DECISION DELEGATED TO HEAD OF PLANNING

Application No: H16-1191-25 **Applicant:** Tulip-Fields Homes Ltd

Proposal: Demolition of redundant commercial buildings and the erection of 4 dwellings

Location: 39-41 Albert Street Spalding

PROPOSED ELEVATIONS

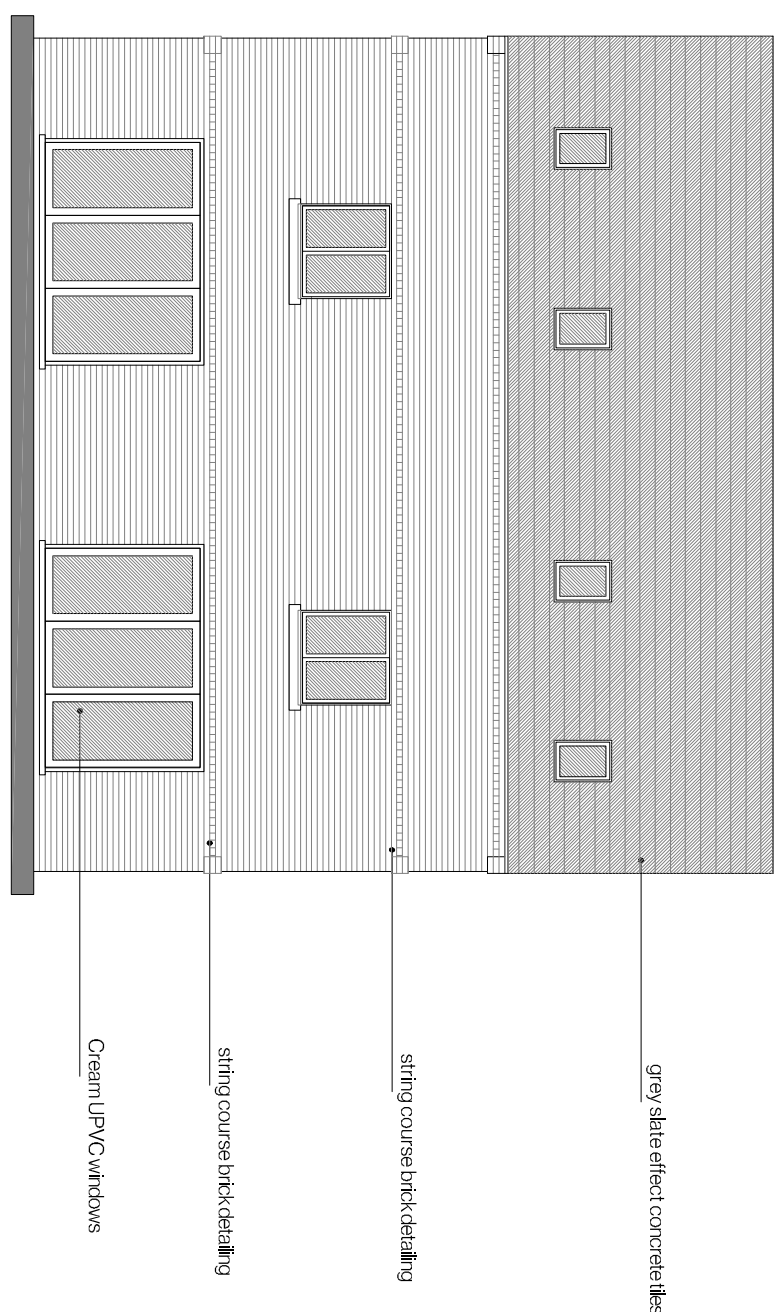
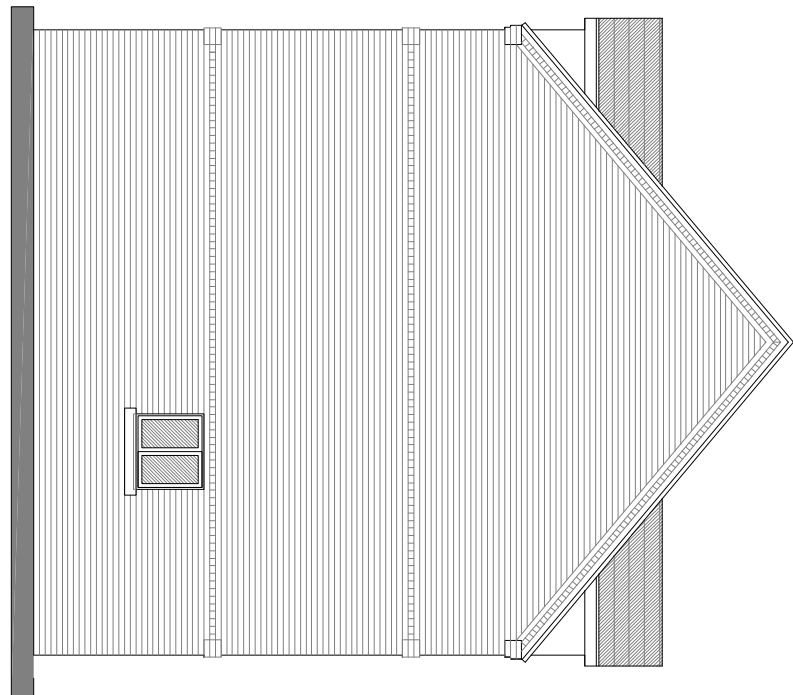
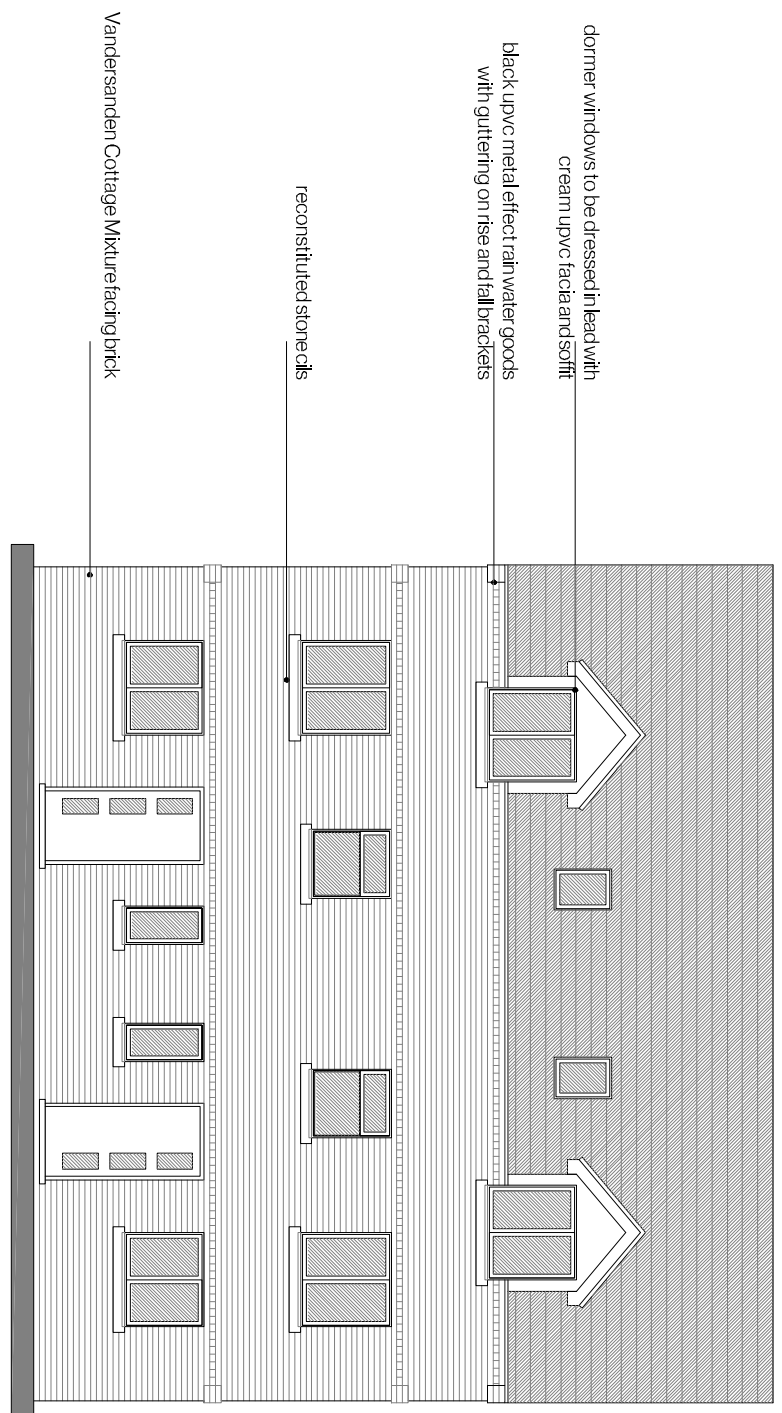
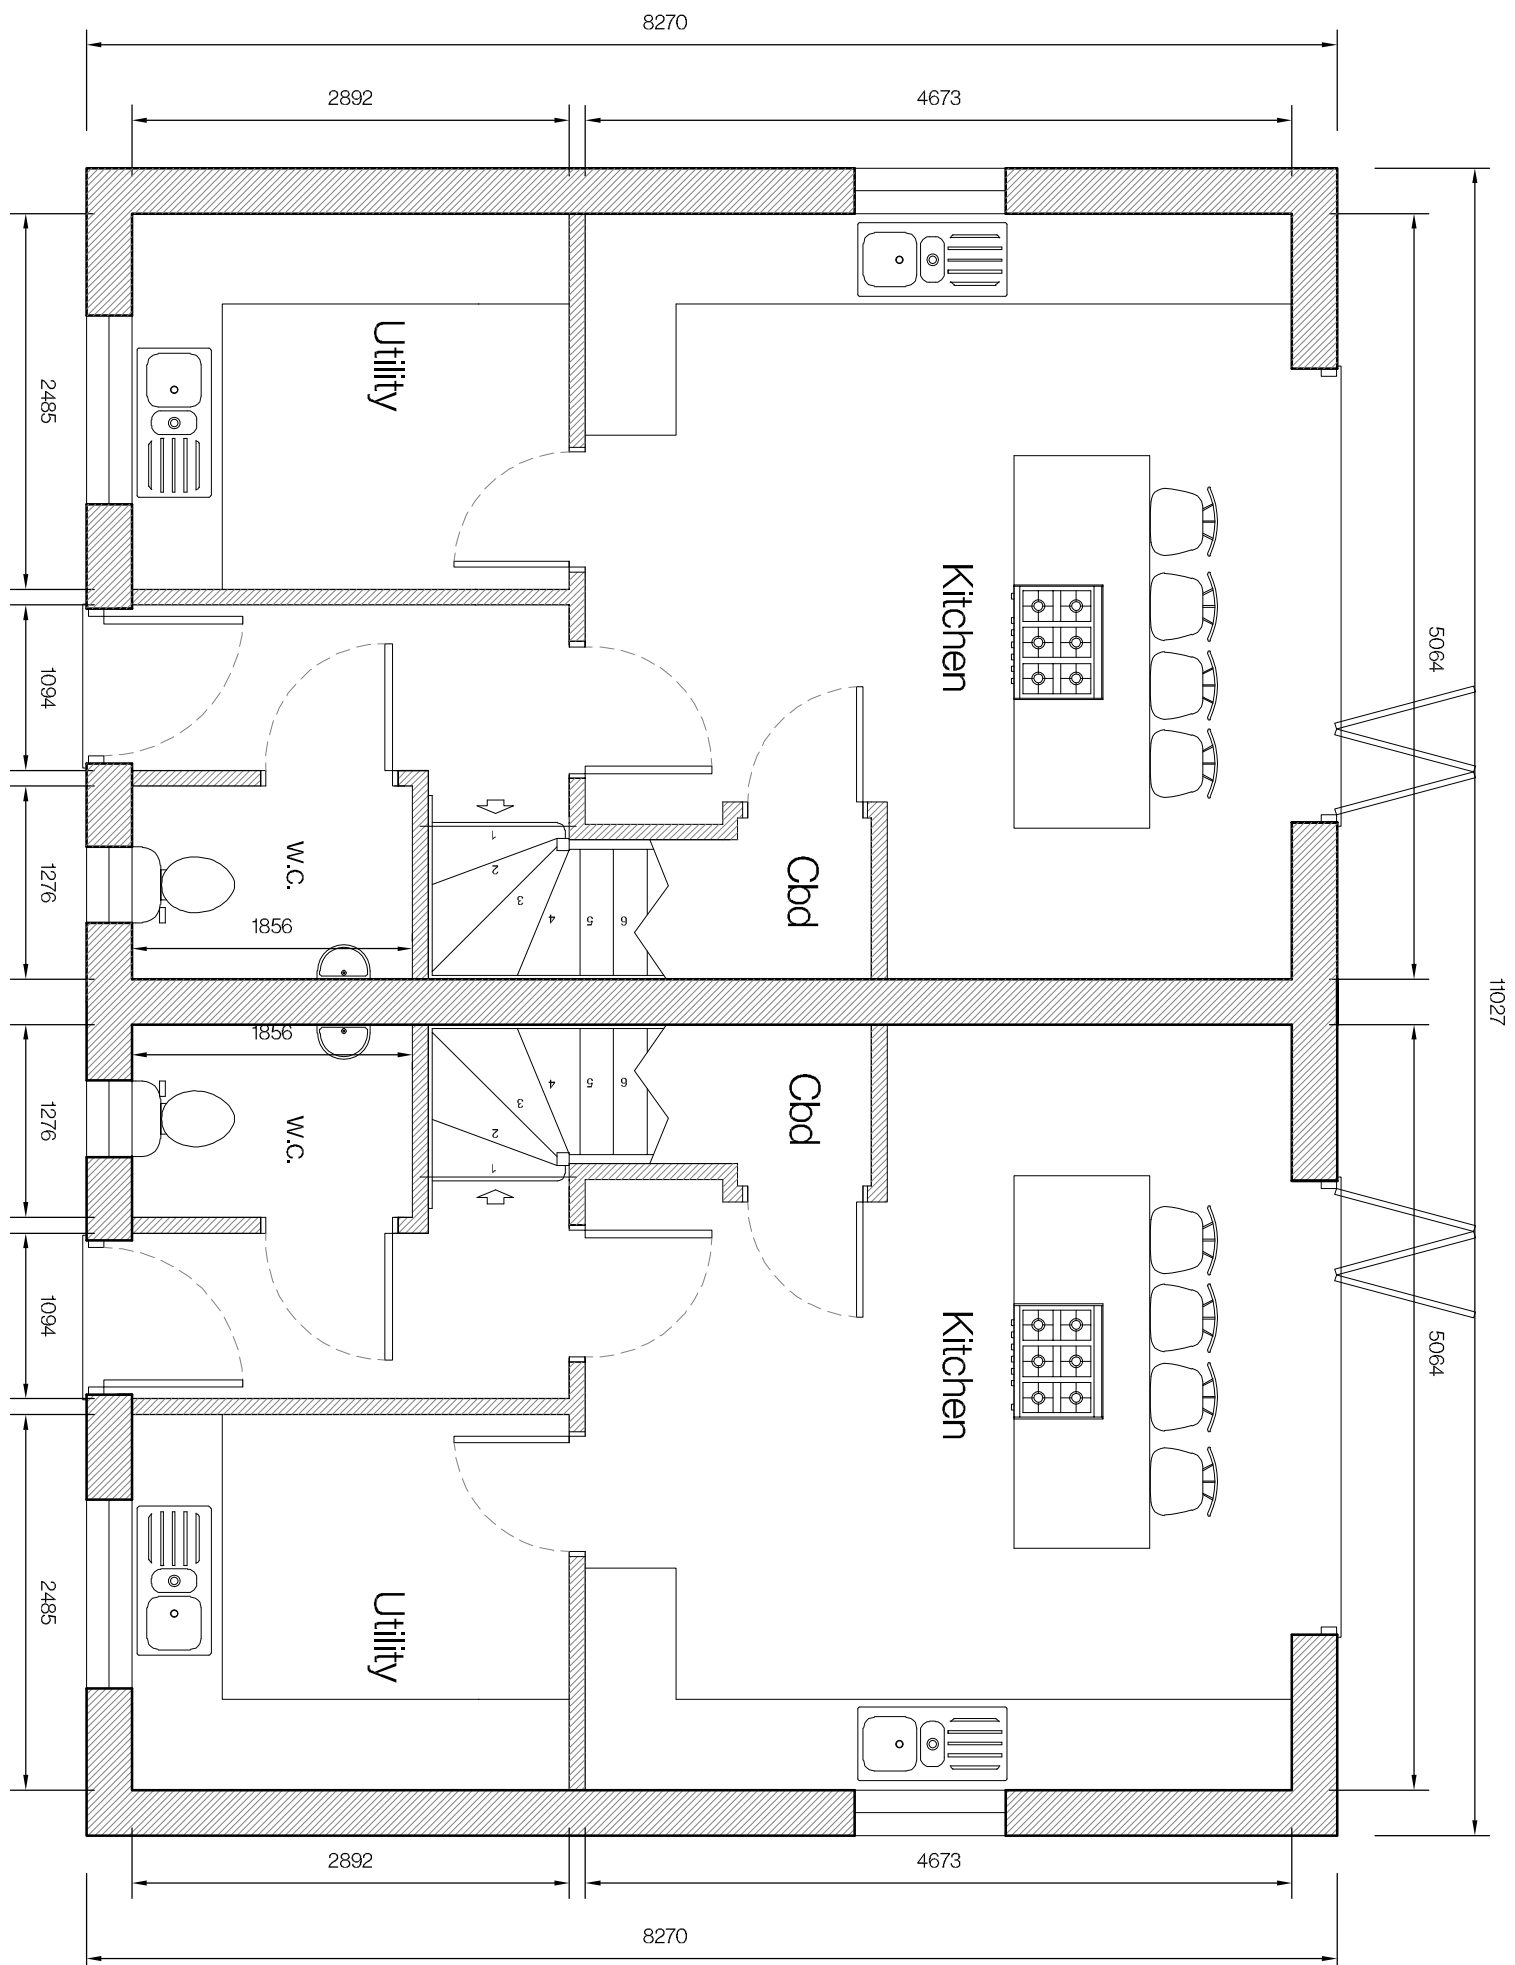
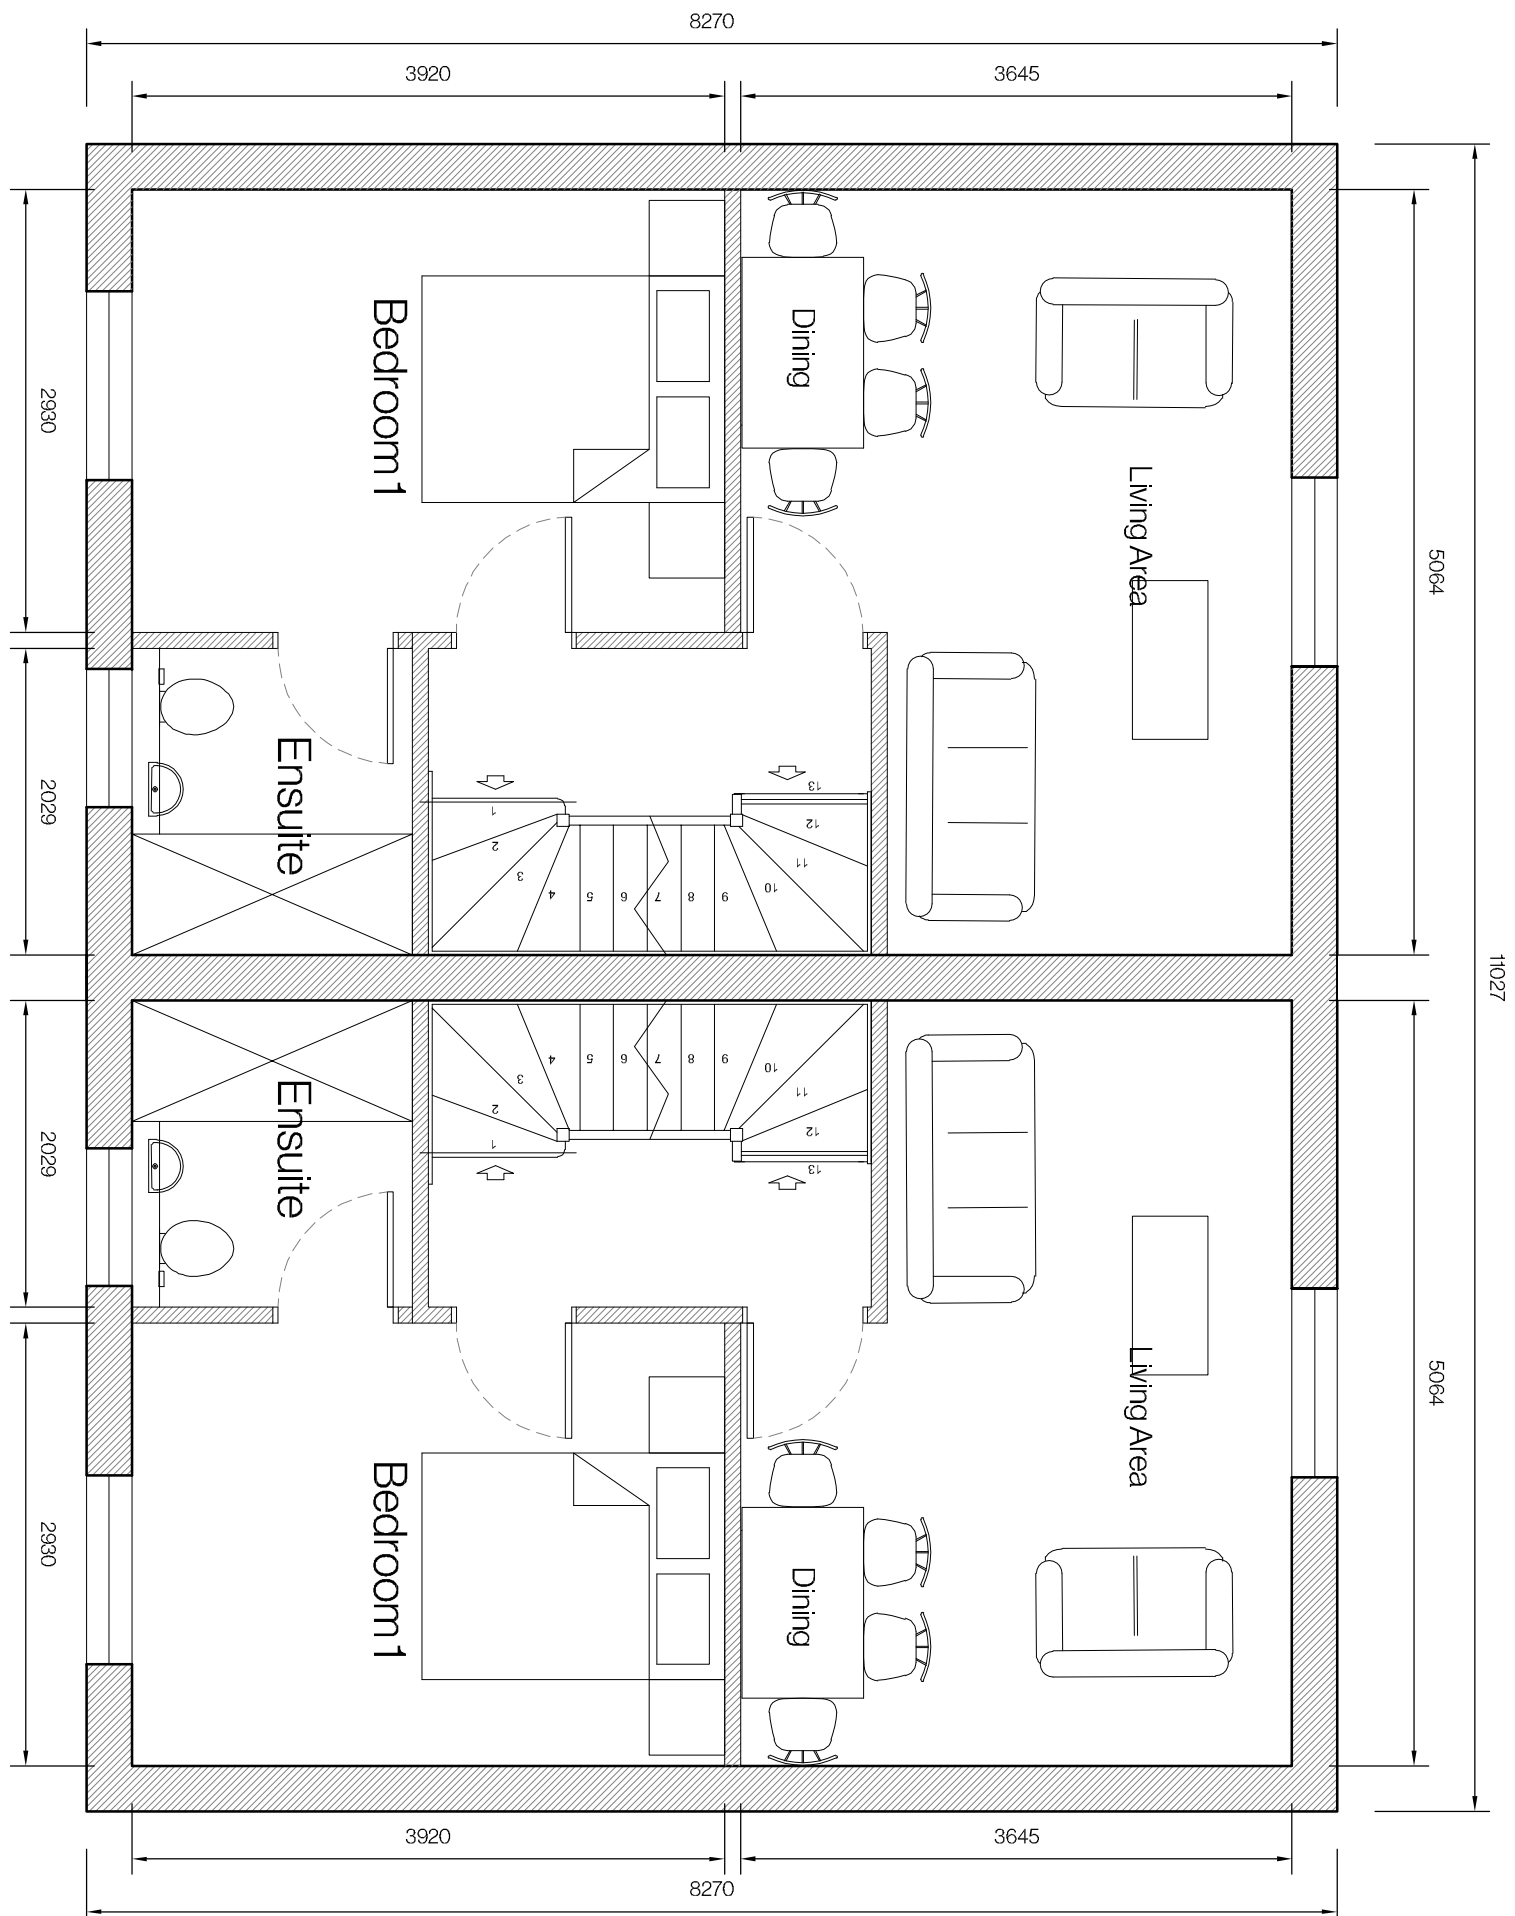
The proposed dwellings would be three-storey and of a significant height. Given the relatively low building heights in the immediate vicinity and the flatness of land, the proposed dwellings would be highly dominant in the street scene and would appear as an incongruous feature. The scale would immediately mark the dwellings as an incompatible feature, which breaks the existing peak of building heights. Paragraphs 53 and 56 of the NDG broadly outline that well-designed development should be influenced by the existing proportions and characteristics of the area. On this basis, as the development would be significantly taller than its immediate counterparts, the proposal would contradict these paragraphs of the NDG.

In addition to marking the dwellings as an incongruous feature, the significant scale in comparison to neighbouring dwellings would equally result in the development appearing highly prominent and overly dominant. The significant height means that the development would be visible within a larger area, including areas of Willow Walk/Osier Road, in turn resulting in a more impactful development. This would result in any negative effects being exacerbated, whilst also fundamentally altering the established character of the area and changing established architectural focal points in the area.

Due to the need to have no habitable space on the ground floor, the proposed living rooms would be on the first floor. The window serving these rooms all face south, towards Willow Walk. These properties do not have sizeable/useable rear gardens, although they do have north facing windows. Due to the orientation of the buildings, the windows of the proposed houses would look directly towards the windows of the relevant properties along Willow Walk. As a result, there would be a tangible overlooking effect, to the detriment of the residential amenity of the affected occupants.
